<b>Consultation Response from KC, Lead Local Flood Authority</b>
<b>2024/93605 Land at, Main Avenue, Cowlersley, Huddersfield, HD4 5US</b>
<b>Erection of 57 dwellings with access from new through road connecting Main Avenue and Windsor Road, and associated works, including engineering and landscaping</b>
<b>Date Responded: 1<sup>st</sup> September 2025 Responding Officer: Paul Farndale Responding Ref: 2</b>

**Further to our comments of 7<sup>th</sup> February 2024, Kirklees Flood Management & Drainage acting as Lead Local Flood Authority largely accepts flood risk and drainage strategies promoted in a revised flood risk assessment, produced by Queensbury Design Limited, revision 5, dated 24<sup>th</sup> July 2025. MINOR ALTERATIONS ARE REQUIRED and OTHER SUBMITTED PLANS SHOULD ADHERE TO THE RECOMMENDATIONS OFF THE FRA.**

PROJECT / CLIENT Kirklees Cluster Sites Main Avenue, Cowlersley		PROJECT NO. N81-3084	
DRAWING TITLE Proposed Materials and External Finishes Plan		DRAWING STATUS Planning	
PROJECT LEADER	DRAWN BY GP	CHECKED BY IDP	DRAWING REVISION P2
SCALE 1:500 @ A1	DATE 22.10.2024

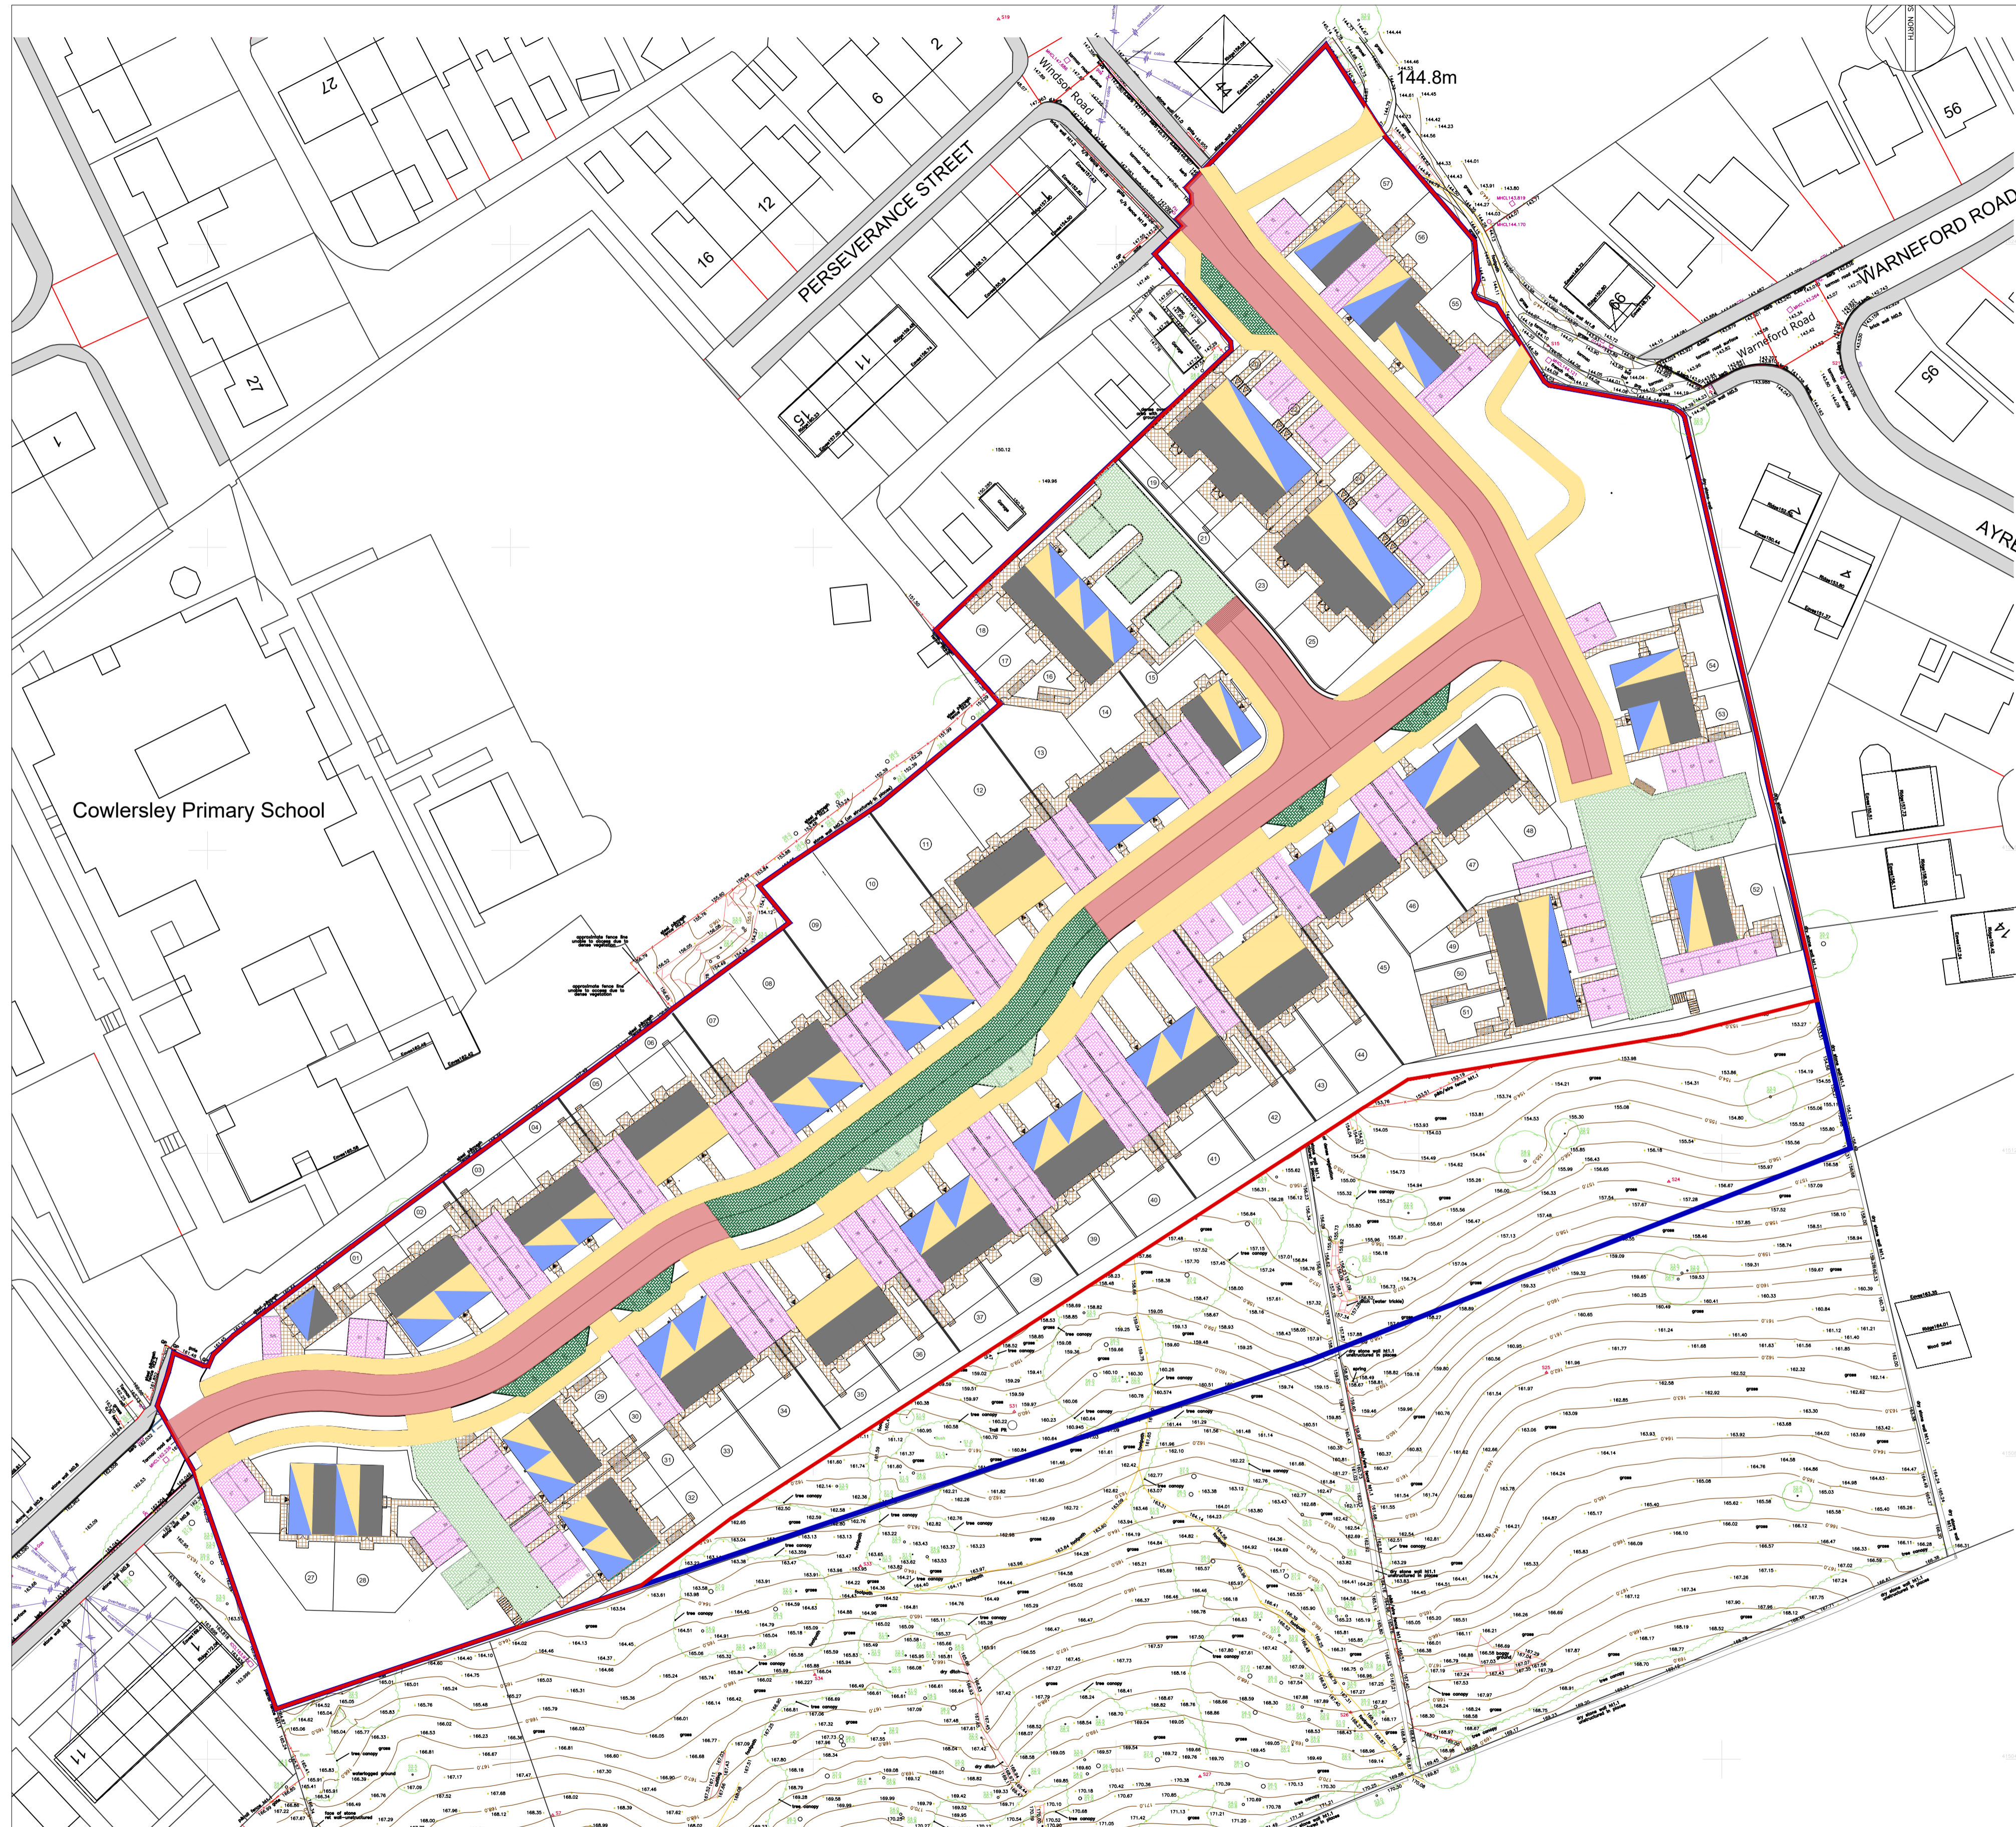
- Flood routing has been incorporated into the design and evidenced. Detail around and adjacent to 66 Warneford Road can be produced via condition as a detailed design.
- The flood risk assessment says the southern boundary will have a parapet wall to aid flood routing. This does not appear to have been considered on boundary treatment plans.
- Other plans have a low spot in the landscape away from the recommend stairs adjacent to plots 51 and 52 at odds with flood routing diagrams. Plans include Landscape Master Plan R/2784/1F (local planting should not interfere with any drainage infrastructure, with a 5m stand off recommended. Other plans showing a low spot away from flood routing are Land Management Plan N81-3084-109, Proposed Site Layout N81-3084-102-P9, a cut and fill exercise the rectify this is required.
